RE: Peter Piper Pizza
Grading and Drainage Plan
Engineer's Stamp Date 2-17-2017 (File: J22D012D)

Re: Peter Piper Pizza
1000 Juan Tabo Blvd NE
Traffic Circulation Layout
Architect's Stamp 02-20-17 (J22-D012D)

Re: Peter Piper Pizza
1000 Juan Tabo Blvd NE
Traffic Circulation Layout
Architect's Stamp dated 03-22-17 (J22-D012D)

PROJECT TITLE: PETER PIPER PIZZA
1000 JUAN TABO BOULEVARD
ALBUQUERQUE, NEW MEXICO
JOB NO.:
DRAWN BY: J.S. SAF
PROJECT MANAGER: JON STERN
SHEET TITLE: TCL SITE PLAN
DATE: 2/1/16
SCALE: 1"=20'
SHEET: 1 of 1

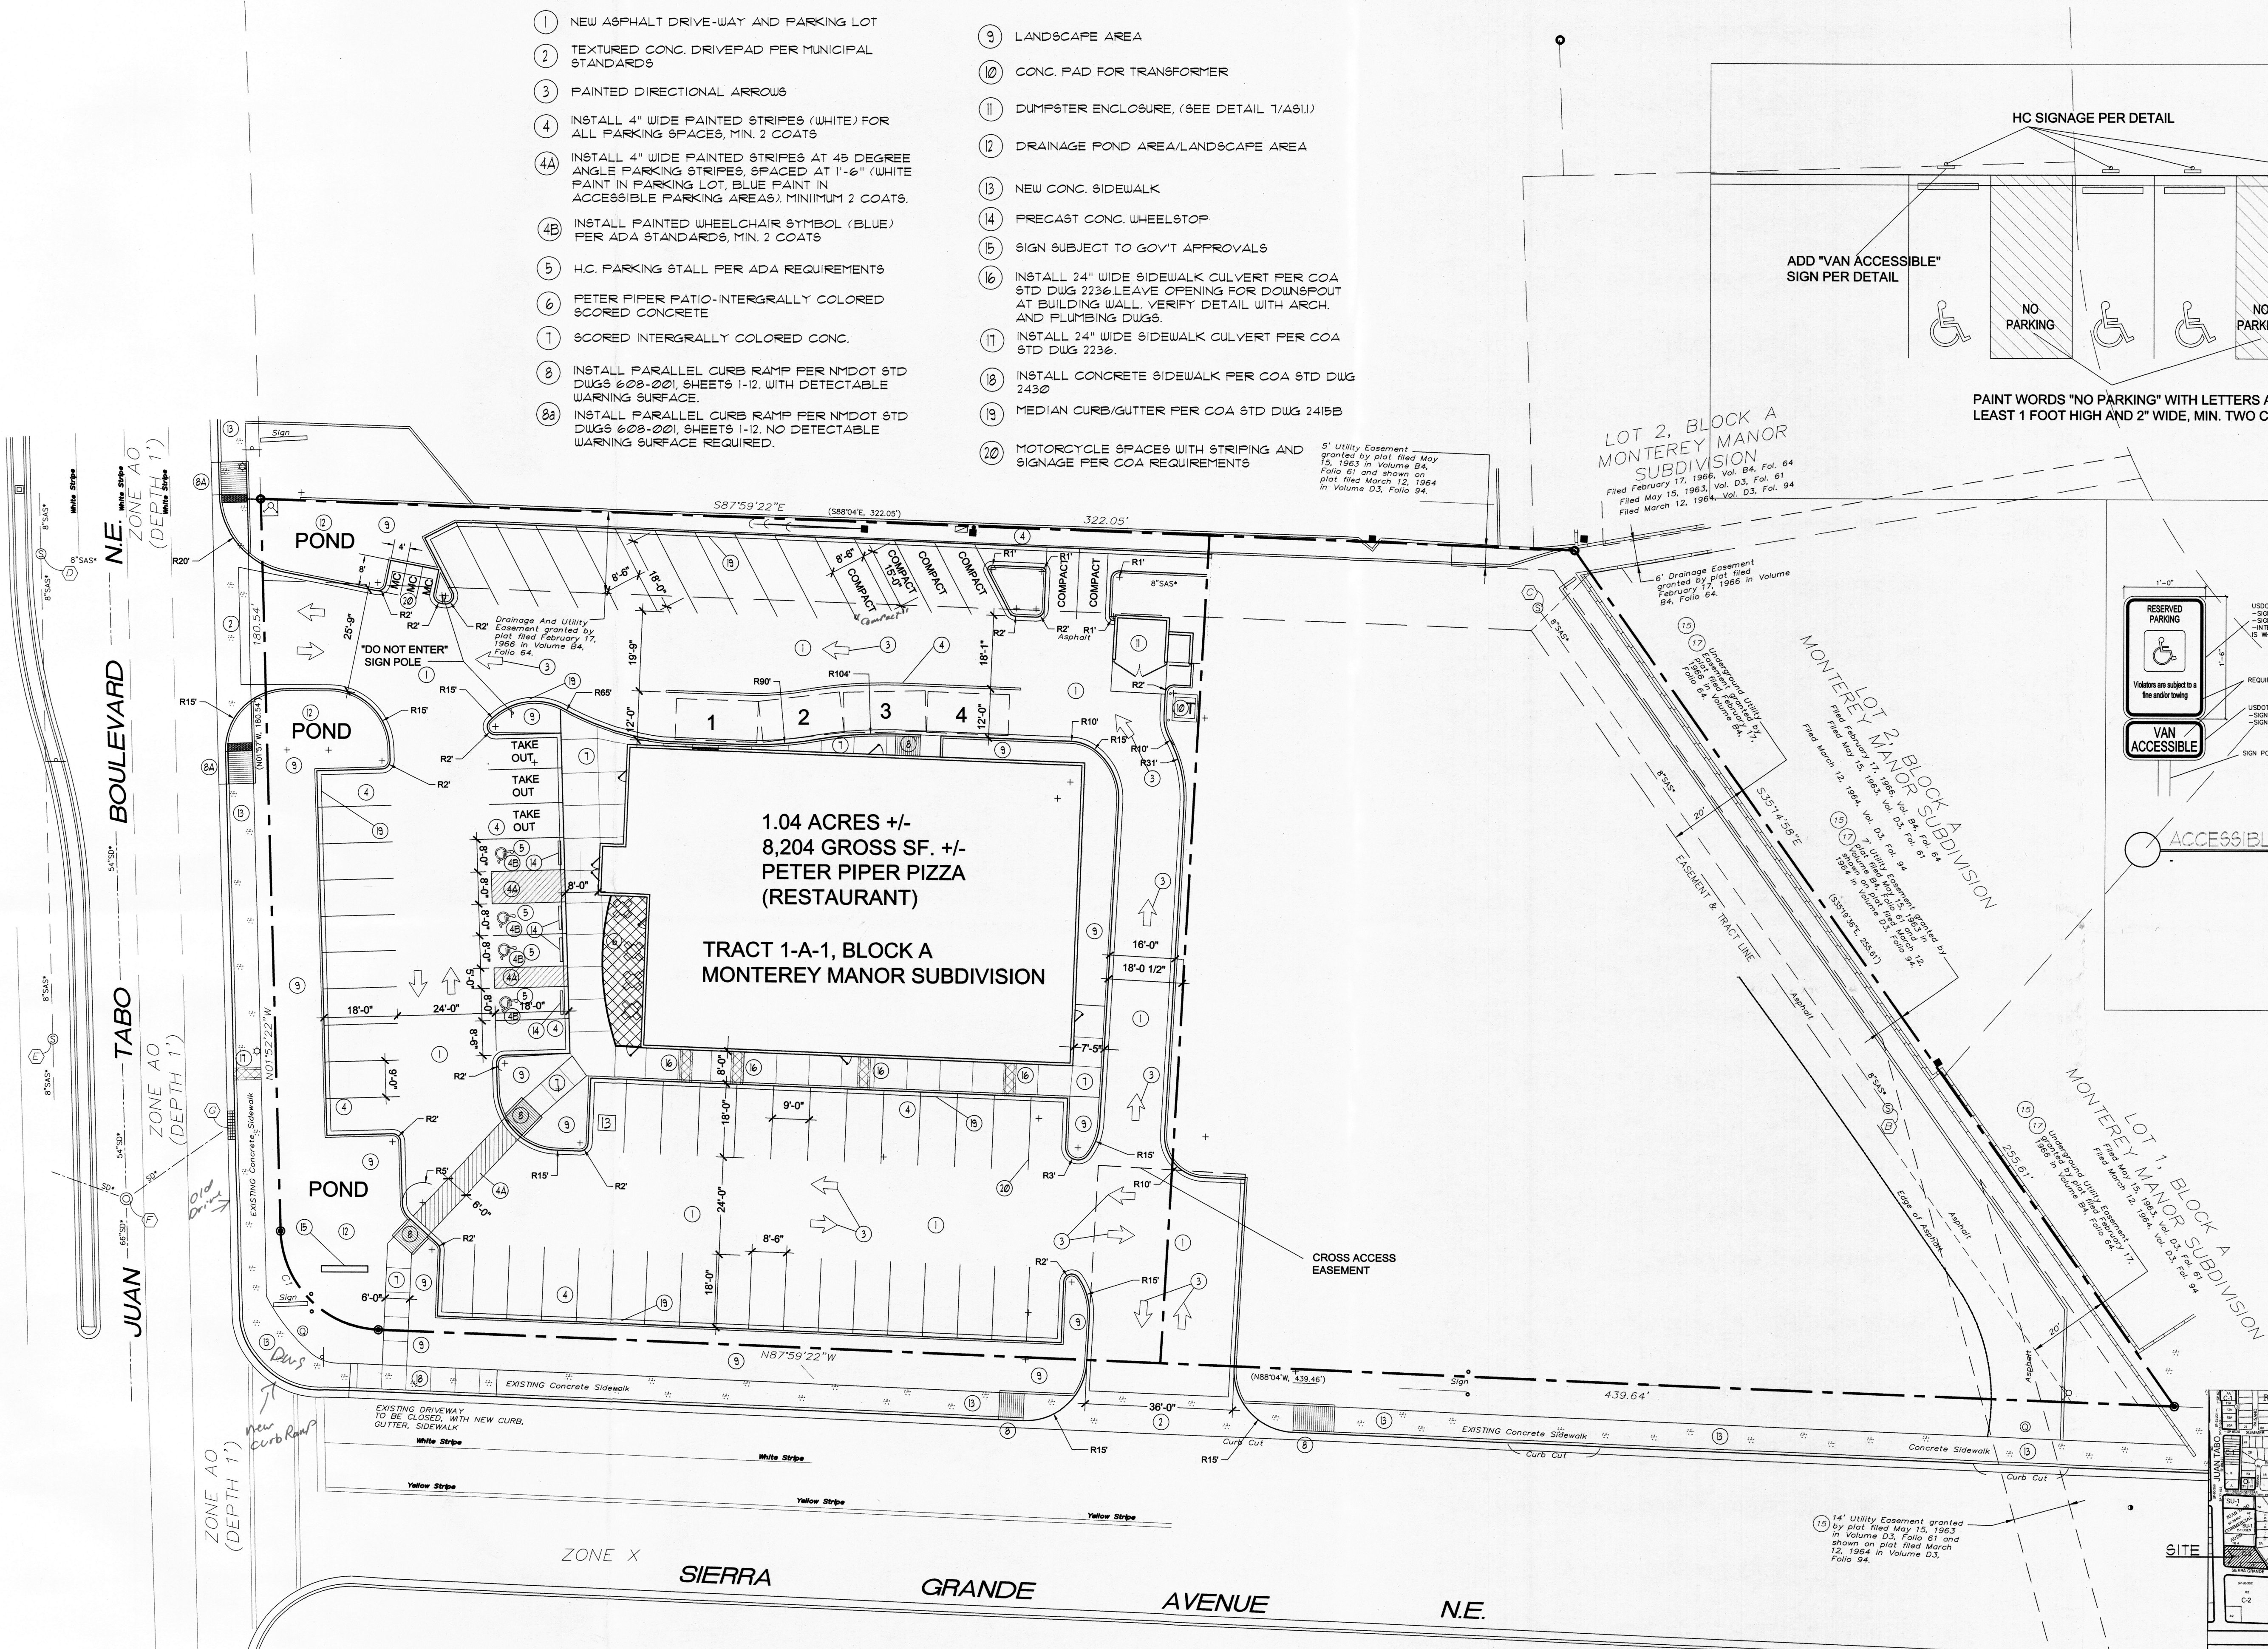
1. Label the compact parking spaces by placing the words "**COMPACT**" on the pavement of each space. Please dimension the spaces. *ADDED KEYNOTE 21*

2. ADA accessible pedestrian pathway should not be placed behind parking space or adjacent to a vehicular way. Vehicle and pedestrian/wheel chair conflicts should be avoided as much as possible. Please clearly show this pathway and provide details. Is a ramp needed to access the building from the ADA parking spots? *CURB IS FLUSH AT ADA ACCESS POINTS*

3. Please specify the City Standard Drawing Number when applicable. Note 13 shows new sidewalk and should use the standard. *NOTE 13 HAS BEEN CHANGED TO "EXISTING SIDEWALK" WAS A TYPOGRAPHICAL ERROR*

4. The ADA curb ramp at the intersection of Juan Tabo and Sierra Grande will need truncated domes installed and should maintain ADA accessibility. *ADDED KEYNOTE 22*

5. Unused curb cuts must be replaced with sidewalk and curb & gutter. A build note must be provided referring to the appropriate City Standard drawing. *DONE*
There is one Curb cut on Juan Tabo that is being closed but is not identified.
